From: Martin Hill <Martin.Hill@arun.gov.uk>
Sent: 17 March 2022 12:23
To: Planning.Responses <Planning.Responses@arun.gov.uk>
Subject: RE: Planning Consultation on: LU/60/22/PL

Comments from Private Sector Housing:

Application No: LU/60/22/PL
Registered: 28th February 2022
Site Address: 27 Clifton Road Littlehampton BN17 5TE
Grid Reference: 502805 101930
Description of Works: Change of use (regularisation and part retrospective) from 11 bed HMO (Sui Generis) to a 20 bed HMO & 2 No dwellings (net gain of 1 No dwelling). This site is in CIL Zone 4.

Project 27 CLIFTON ROAD, LITTLEHAMPTON BN17 5TE		
Title PROPOSED REAR AND SIDE ELEVATION		
Drawn By DH	Checked ASPIRE	Date JAN 22
Drawing Number 1714-16	Revision -	Scale 1:100@A3
Client -

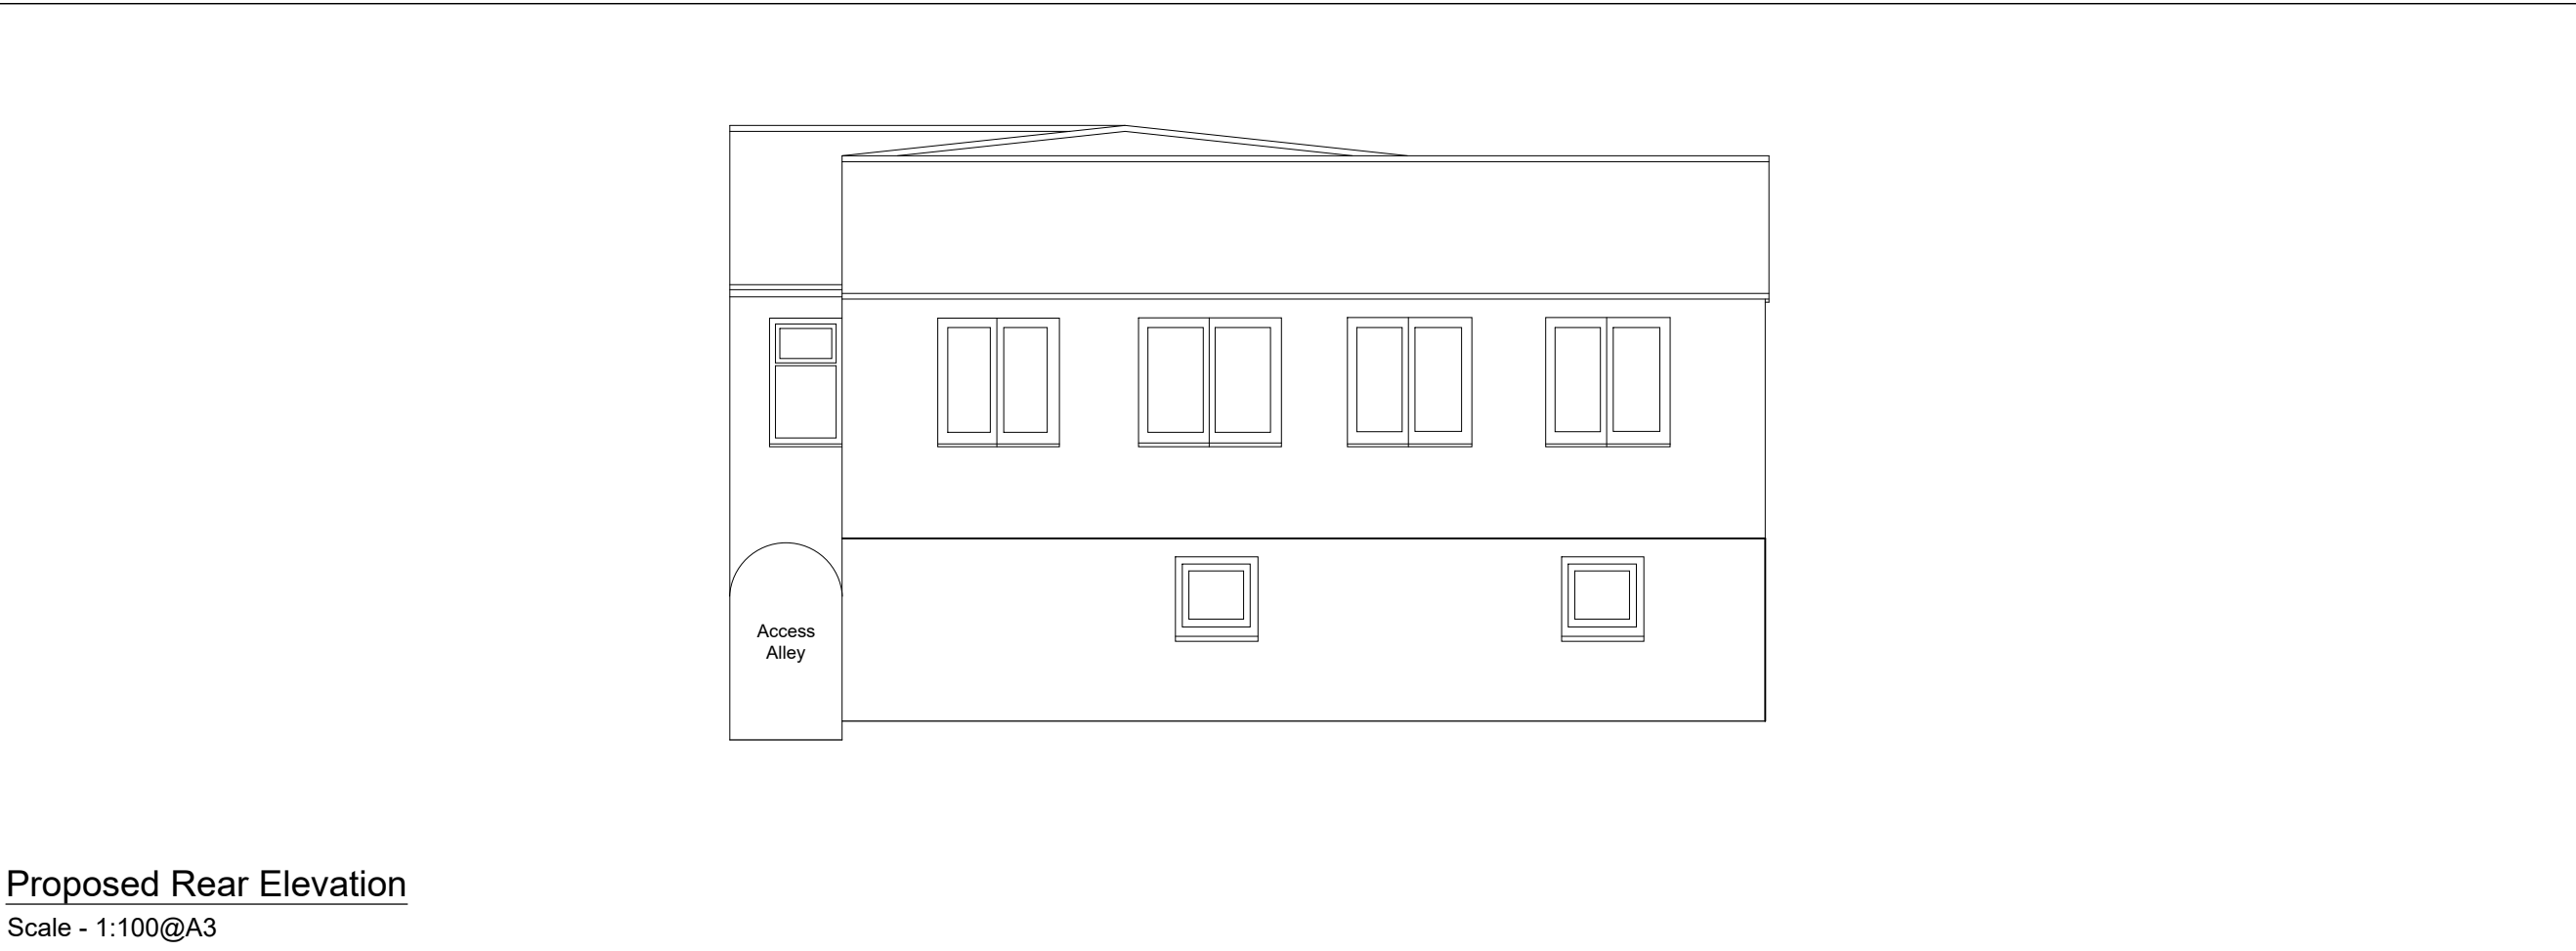
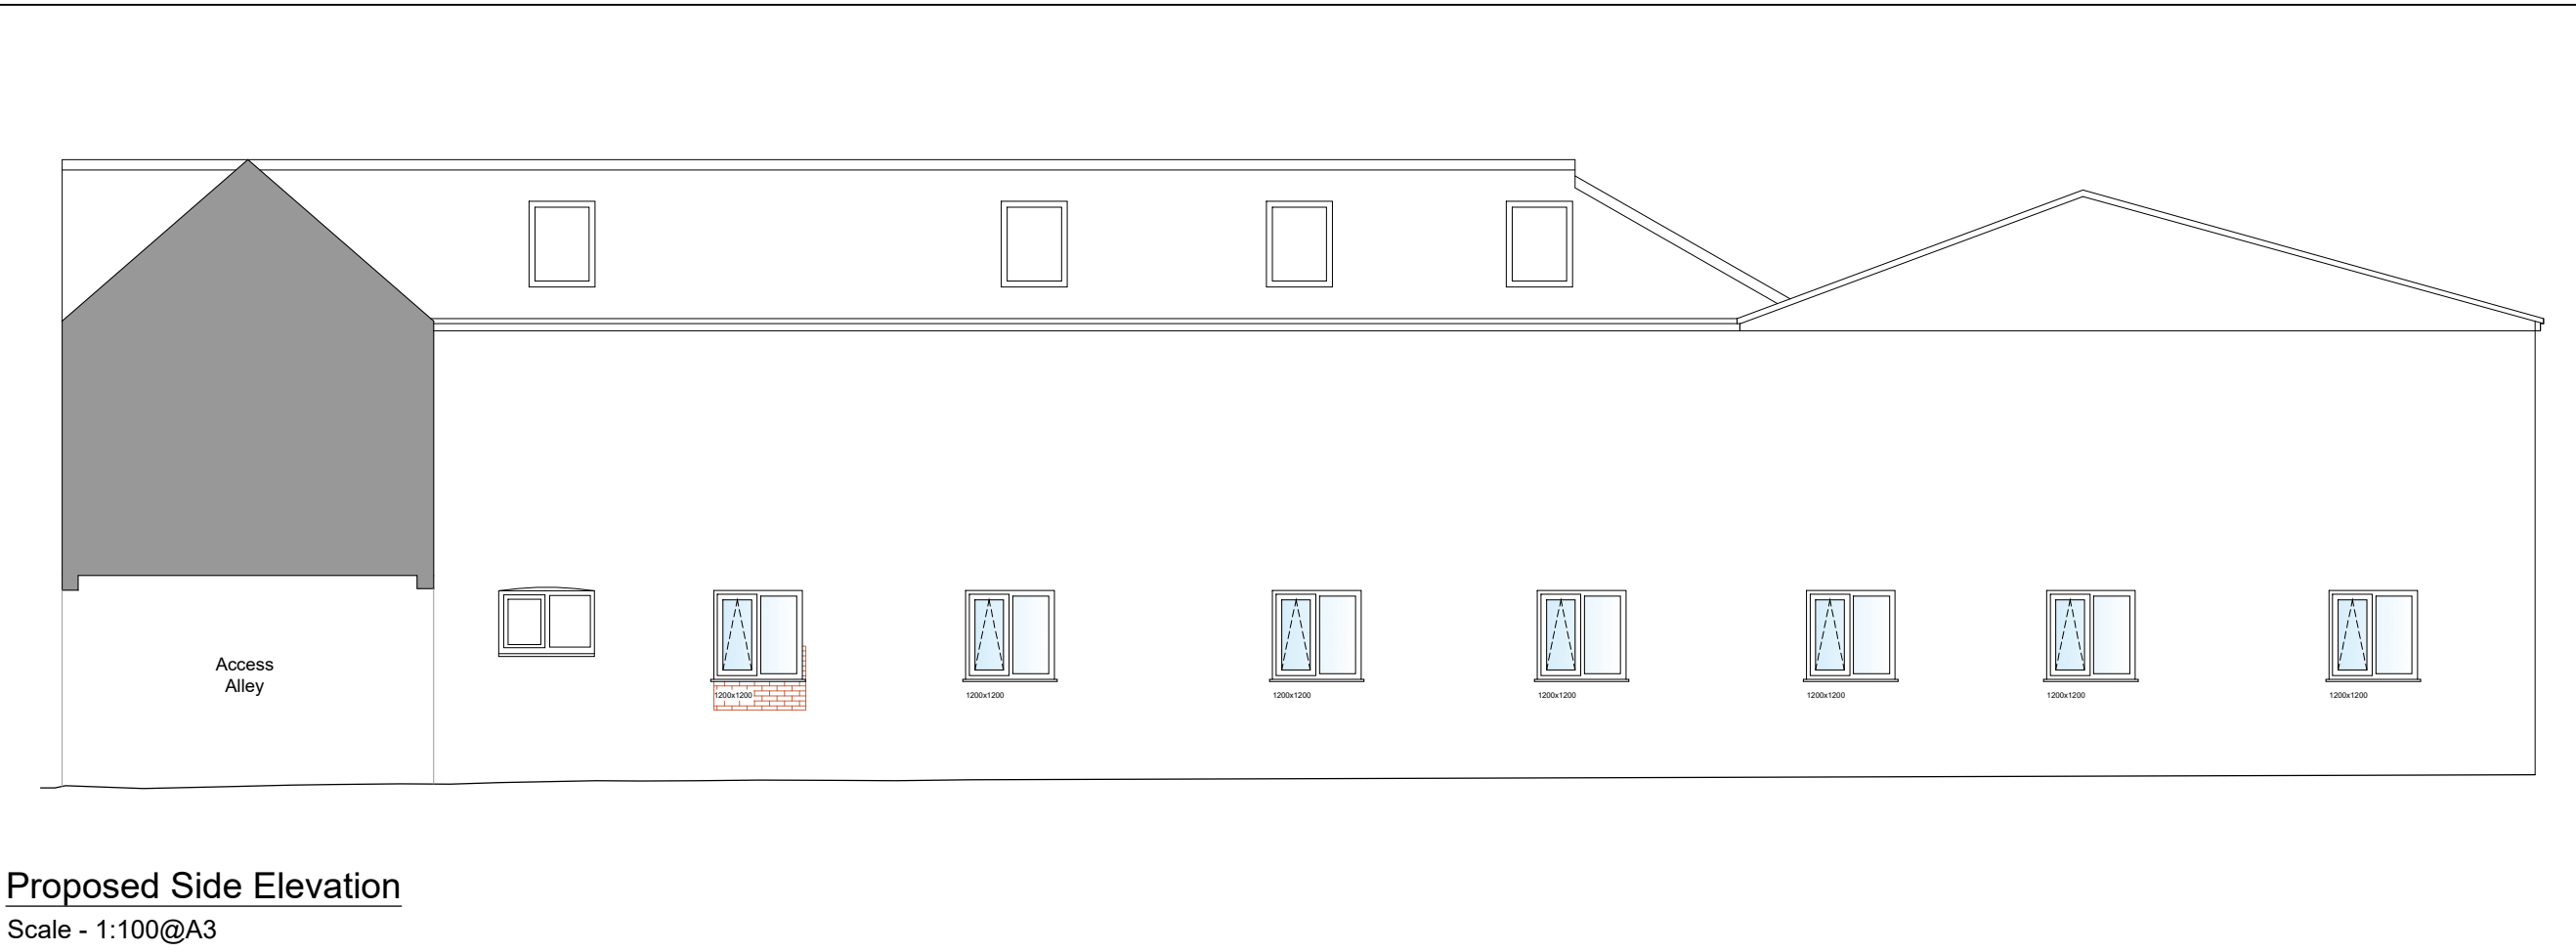
- The external staircase serving the first floor HMO is the sole means of escape from this level, therefore it should be protected from the effects of fire along its entire length. The sensitive area is 1.8m horizontally therefore any windows in this region should be of fire resisting construction and fixed shut. Any doors opening onto the sensitive area should be fire resisting and self-closing.

- o Fire blanket to be provided in each communal kitchen
- Install a suitable barrier to protect the access/egress point on the ground floor from parked vehicles or other obstructions that may impede the means of escape. The same principle should be applied to protect the access/egress stair serving the first floor.

- Any safety guarding/railing fitted must be a minimum 1100mm high and any gaps between railings and/or spindles must be less than 100mm.

Title  
PROPOSED GROUND FLOOR PLAN

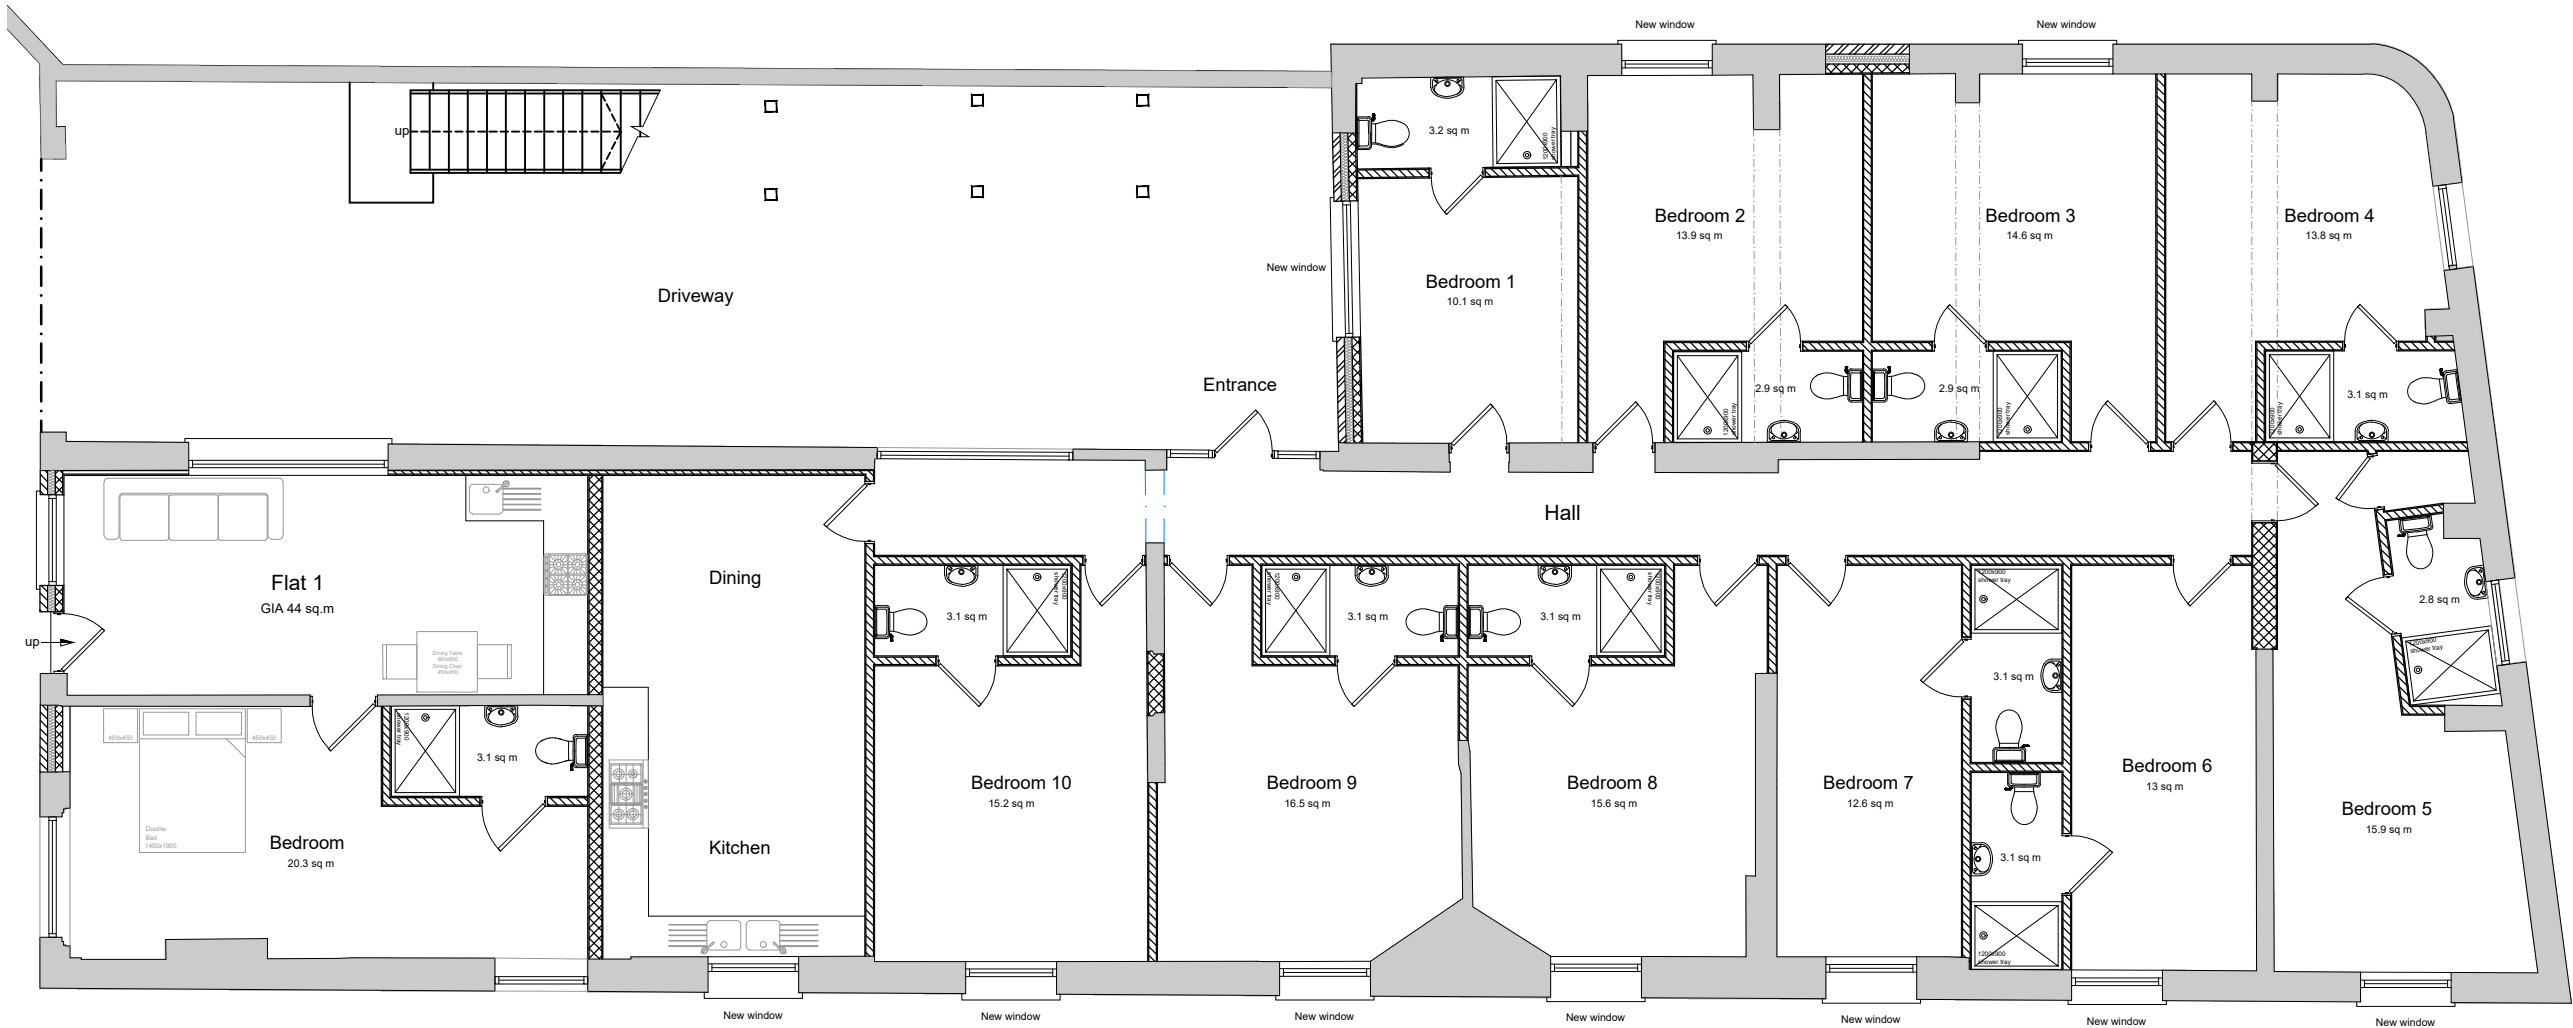
- A room where the only escape route is through another room is termed an “inner room” and poses a risk to its occupiers if a fire starts unnoticed in the outer room. The escape route from the bedroom in Flat 1 is via the kitchen-diner; this can be overcome by ensuring that

the window in the bedroom of flat 1 meets the requirements of an escape window and adequate fire protection provided in the form of a fire door separating the bedroom and kitchen area, together with interlinked smoke detection in both the kitchen-diner area and the bedroom within the flat.

- 30min fire resisting escape route in both the ground and first floor HMOs and providing an FD30S standard fire resisting and self-closing fire door to each risk room (bedsits, kitchen-diners, offices and any cupboards located in the escape route). This will include 3 fire rated steel hinges, intumescent strips and cold smoke seals and an overhead self-closing device conforming to BS EN 1154, minimum Power Size 3.

- Grade D1, LD2 fire alarm and detection system covering both storeys of the entire building;
 - o interlinked mains wired smoke alarms with tamper-proof integral battery back-up located throughout each escape route.

- Thumb turn opening devices to be fitted to all bedsit and final exit doors to enable escape from the building without the use of a key, code or card.
